**GAZECORP INDUSTRIAL ESTATE – 813-913 WALLGROVE ROAD, HORSLEY PARK
– ADVICE FOR SSD-5248 (MOD 1) – REVISED LAYOUT AND EARTHWORKS**

The Gazcorp Industrial Estate is located within Western Sydney Employment Area, situated within the north-western portion of Fairfield LGA. Council officers have reviewed the Modification Report prepared by Ethos Urban dated 12 April 2021 and the relevant technical documents and provide the following comments:

STORMWATER CONCEPT PLAN

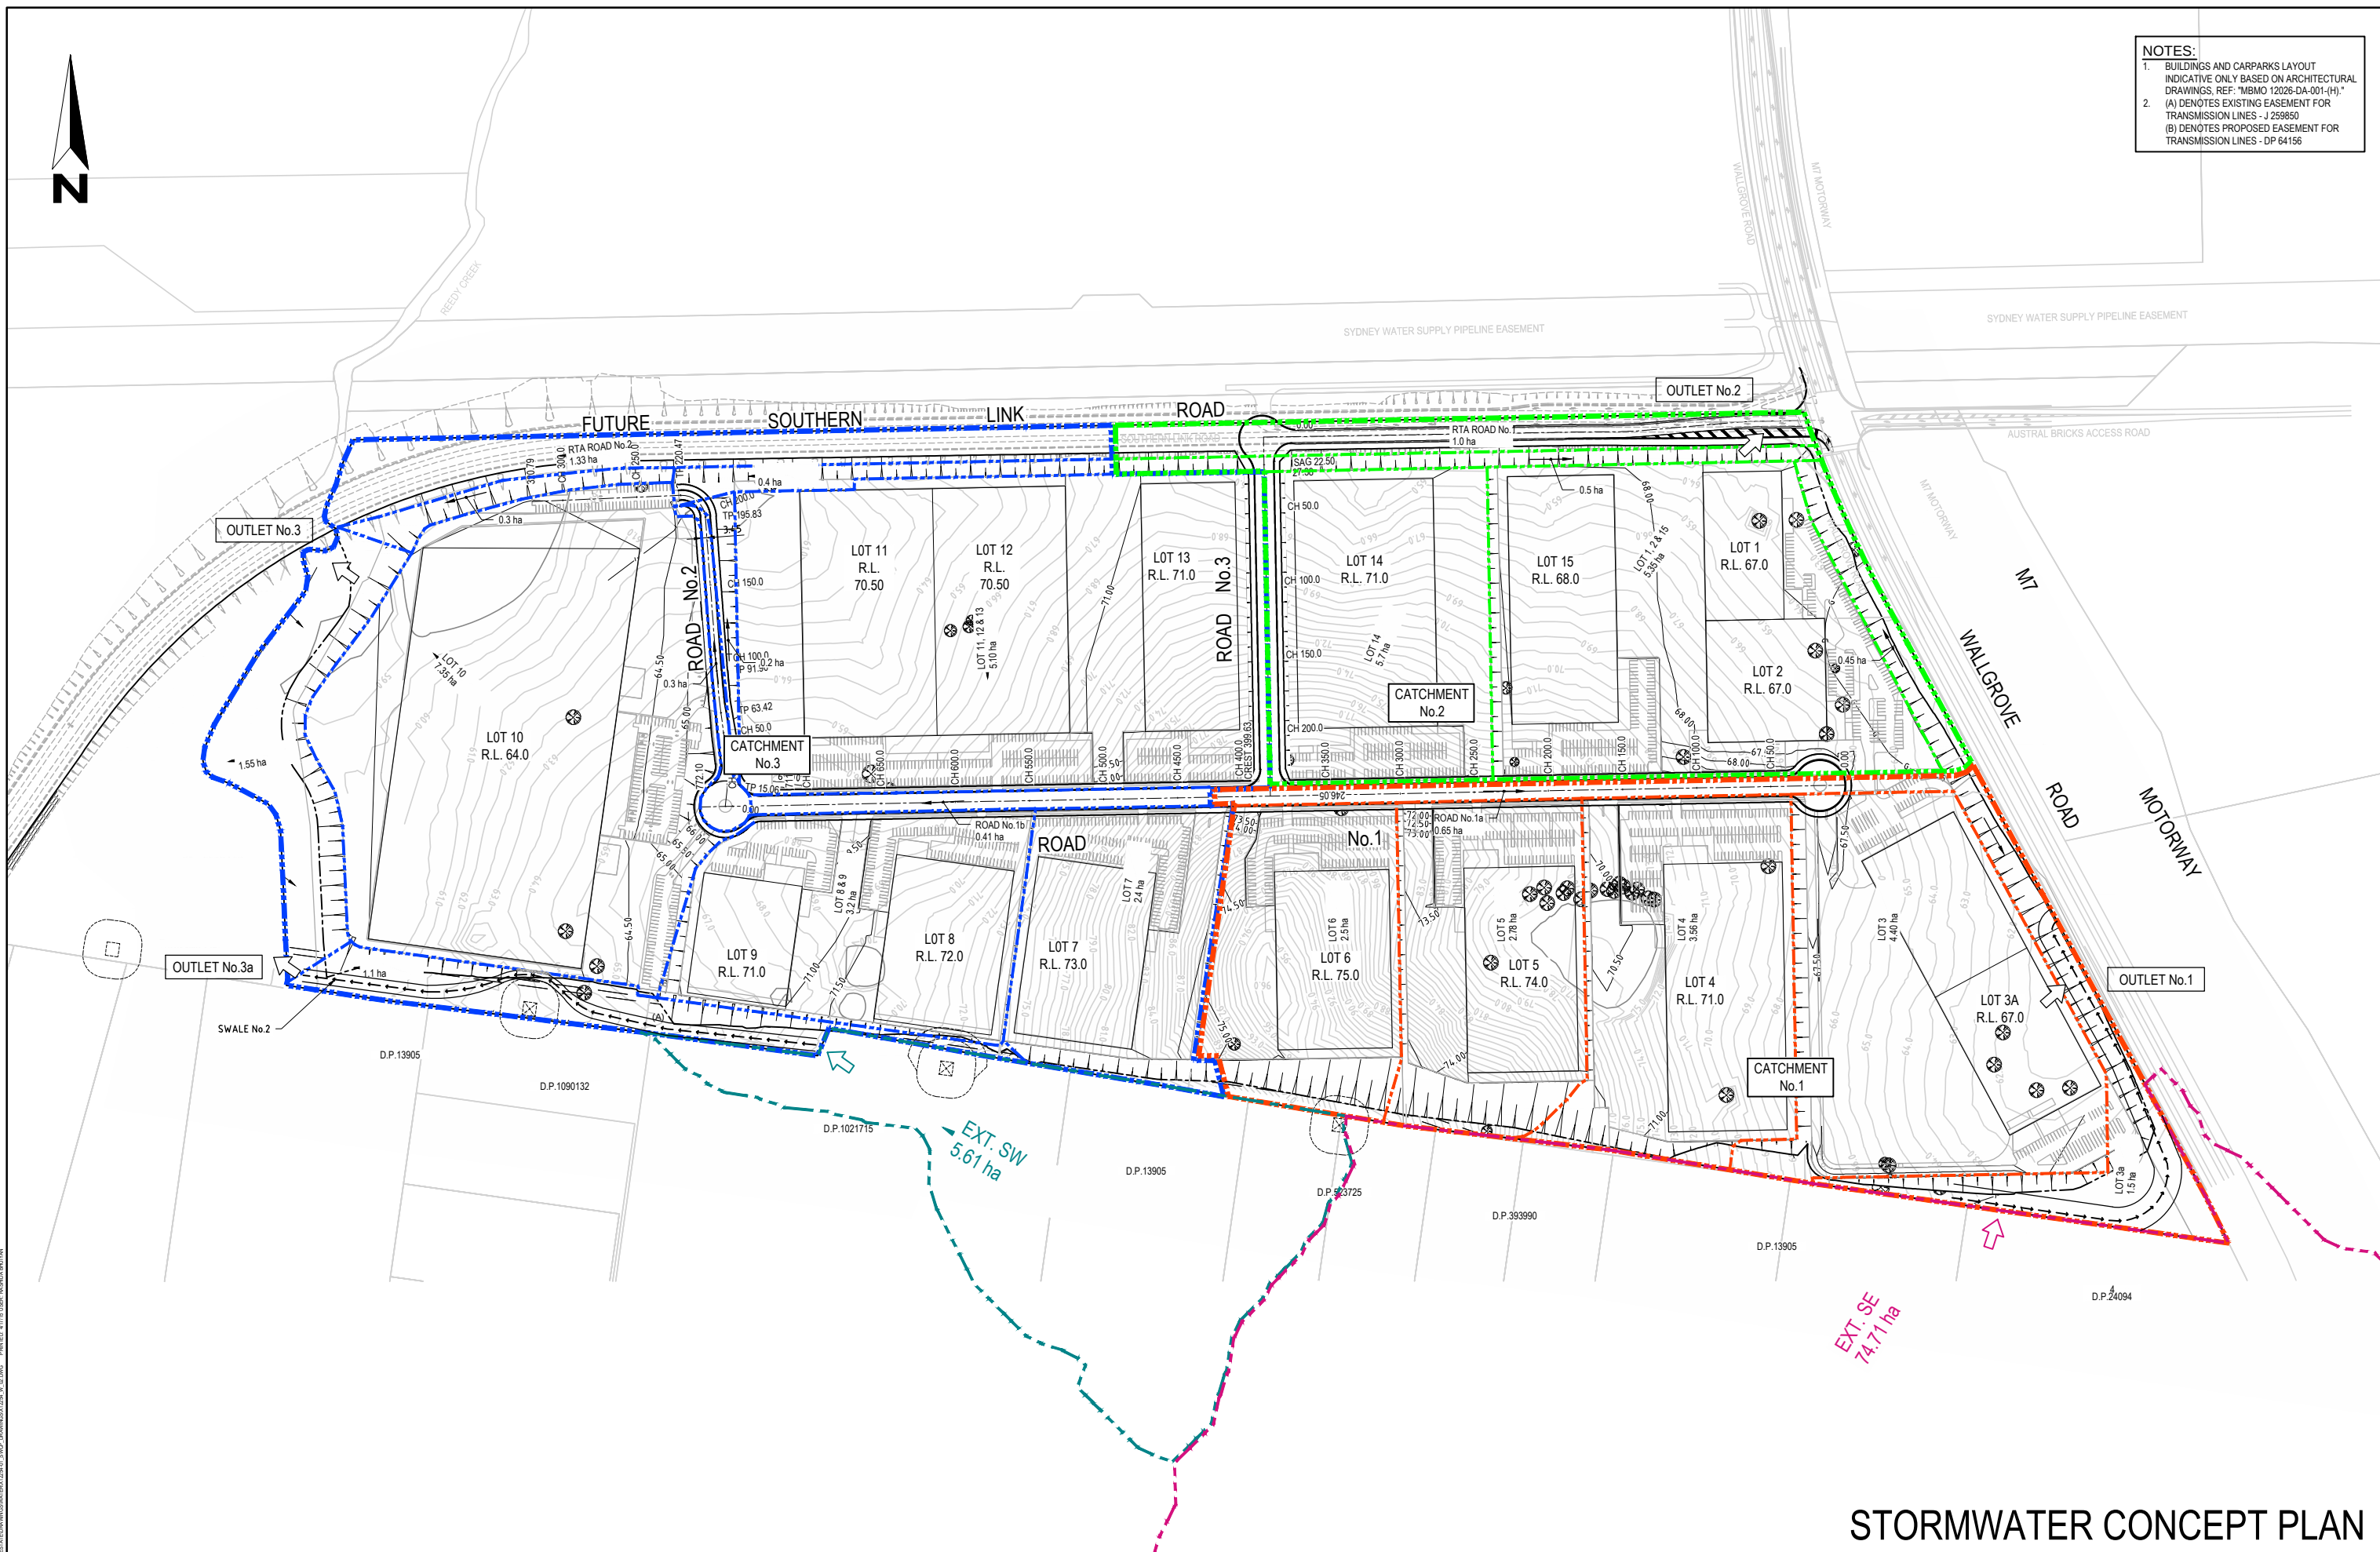
Furthermore, the stormwater plans prepared by Orion Consulting Project No. 19-0108, Sheet DA 200(B) is not acceptable in its current form. Details of pipes and pits within the access road and details of all final discharge points shall be included in the stormwater plan. Drains model or similar program that was used in the design shall be submitted to Council.
